SITE PLAN
 14625 MILLHAVEN PLACE
 COUNTY OF EL PASO, STATE OF COLORADO

CATHEDRAL PINES SUBDIVISION FILING NO.2, LOT 51

AN AMENDMENT TO LOT 51, CATHEDRAL PINES SUBDIVISION FILING NO.2

# CATHEDRAL PINES SUBDIVISION FILING NO.2, LOT 51

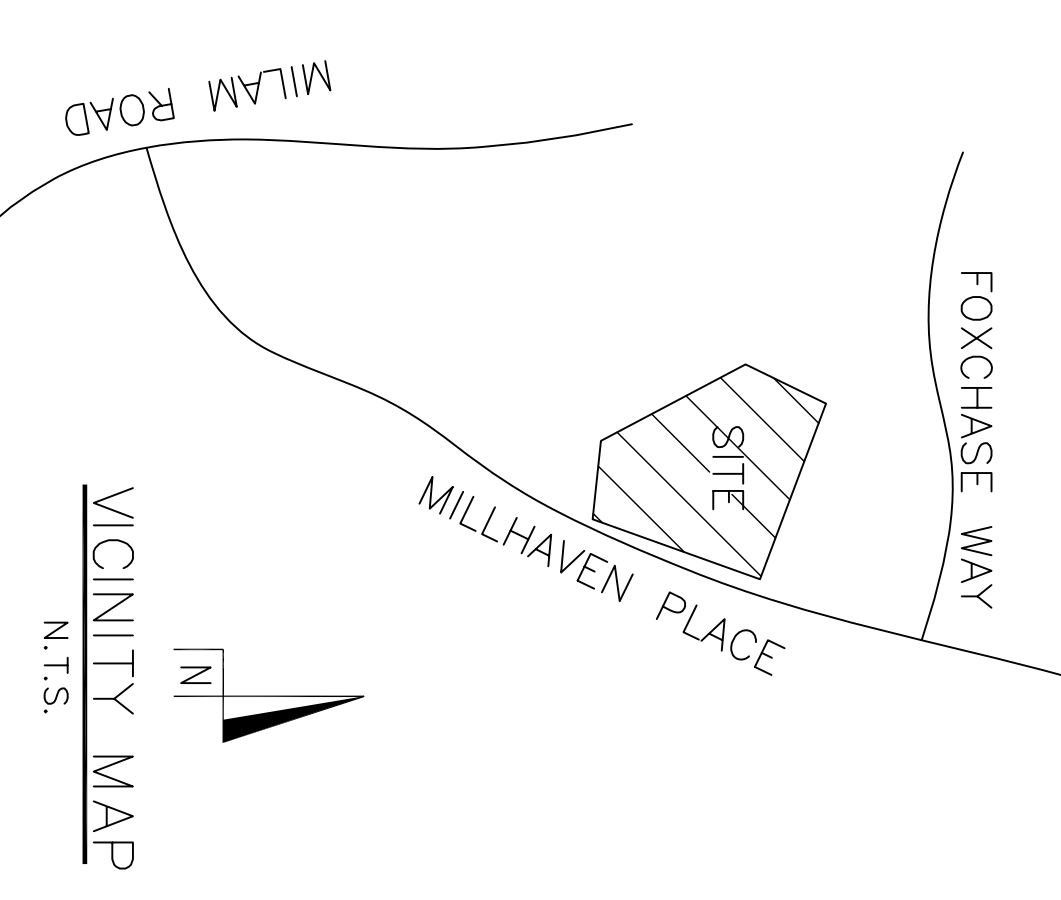
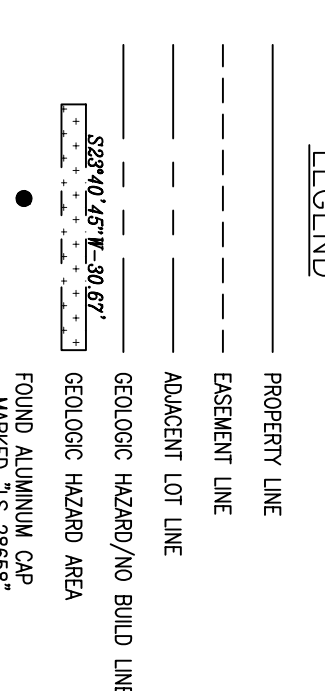
RECORDING: Chair, County Commissioners)
State of Colorado)
County of El Paso)
Remove this approval)
signature block unless you)
want the application to go to)
BOCC, but an extended)
approval will be required)
I hereby certify that this instrument was filed for record in my office at _____ o'clock _____ M., this ____ day of _____, 20__ A.D., and is duly recorded at Reception No. _____ of the records of El Paso County, Colorado.

NOTE: note 1 needs to address the reason for the amended plat

needs to be removed all notes added to plat
original plat, missing notes are 7, 10, 11, 12, 13, 14, 15, 16, 18, 19, 23, and 23, note 14

All notes should be transferred over from the original plat, missing notes are 7, 10, 11, 12, 13, 14, 15, 16, 18, 19, 23, and 23, note 14 needs to be removed all notes added to plat
